**SSD 9343 Meadowbank Education and Employment Precinct Schools Project**

Thank you for your correspondence via Major Project portal (ref: PAE-812) on 18 October 2019, requesting Transport for NSW (TfNSW) to review and comment on the above. This letter is offered as a collective response from agencies of the Transport cluster including Roads and Maritime Services and Sydney Trains.

## Attachment A – Comments on SSD 9343

Figure 18 – Proposed Kerbside Facilities

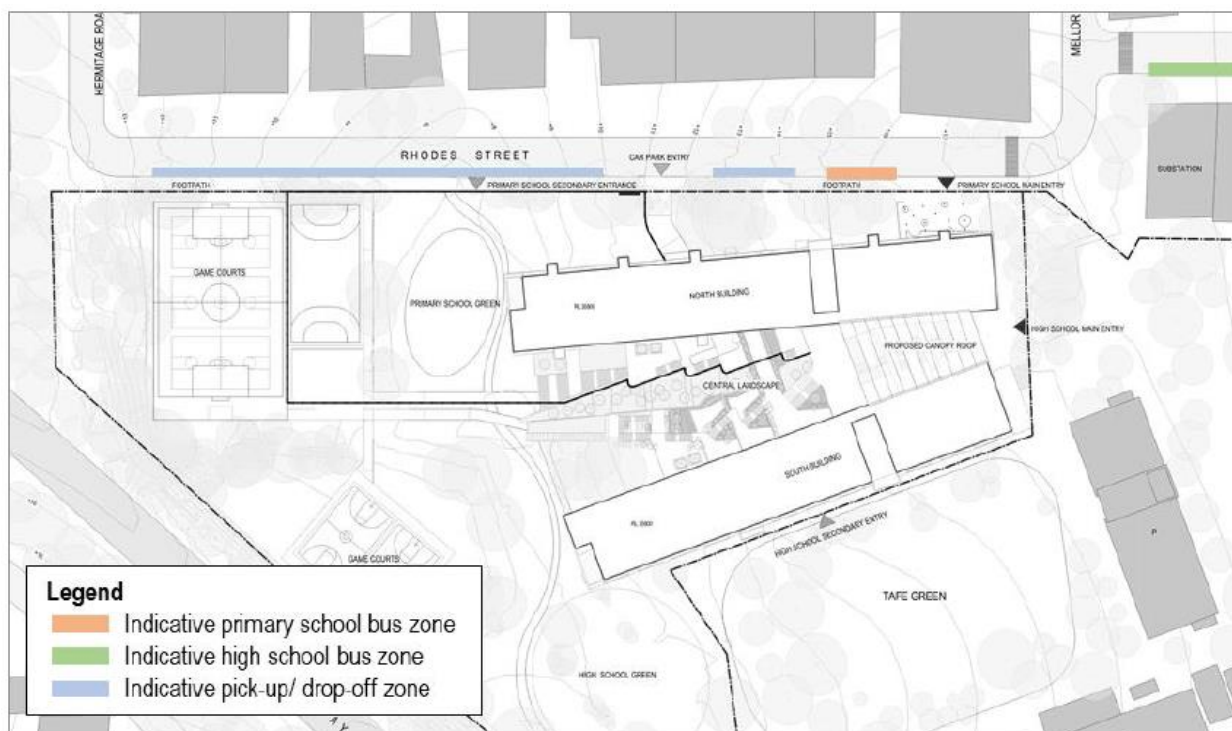
- According to Section 9.6, the proposed primary school bus zone on Rhodes Street is planned to service two buses. It is advised that the proposed bus zone length of 20m would not be adequate for two buses. Notwithstanding, data presented in Table 7.3 indicates that 0% of primary school students use bus for regular travel to and from school.
- The mode share for the secondary school indicates 26% of students arriving by bus, for which a bus zone is proposed on MacPherson Street. There is a list of local road improvements proposed to support the school bus routes. Further details are requested to confirm the feasibility of these improvement works and design of these facilities.

As part of the Response to Submissions (RtS), swept path analysis should be provided for buses on all streets between Victoria Road and the proposed bus zone locations to ensure the surrounding streets are capable of accommodating the future school bus services. Turnaround facility on Rhodes Street with access for all services via Hermitage Road should also be considered to better facilitate the future traffic generating from the school sites. The proposed length and allocation to Primary school of a bus zone on Rhodes Street should also be further reviewed for servicing the proposed two school bus stops.

Figure 9.1: Existing intersection layouts - SIDRA Network

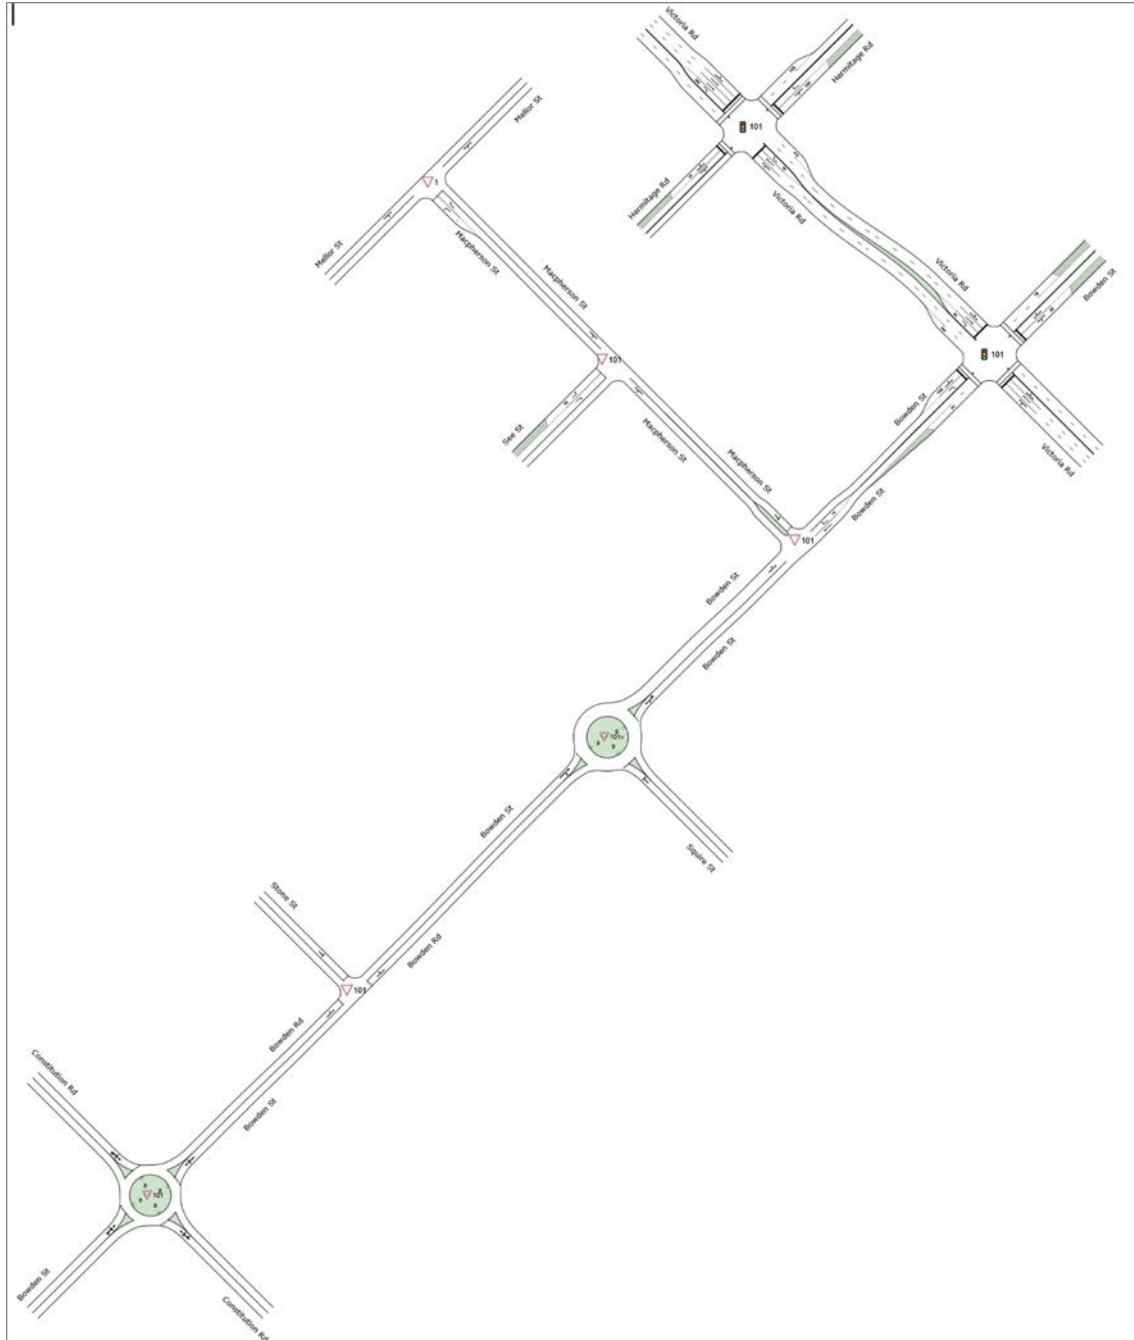
- Figure 9.1 SIDRA Modeling layout shown for Bowden Road and Stone Street shows stop lines present on all approaches. Bowden Road should not have any stoplines present. The SIDRA network layout also does not reflect street parking and bus stops on the kerbside.

- Provide justification for the adopted gap acceptance factor in accordance with the methodology for calibrating gap acceptance per SIDRA recommended practice.
- Clarification is required on the methodology used to understand the distribution of trips as outlined in the comments above. Further assessment may be required on the local network surrounding the proposed school site.
- SIDRA model layout should accurately represent the present and future conditions.
- The total trips and directional split (inbound and outbound traffic) shown in Table 9.1 needs to be clarified in reference to the above discussed comment.
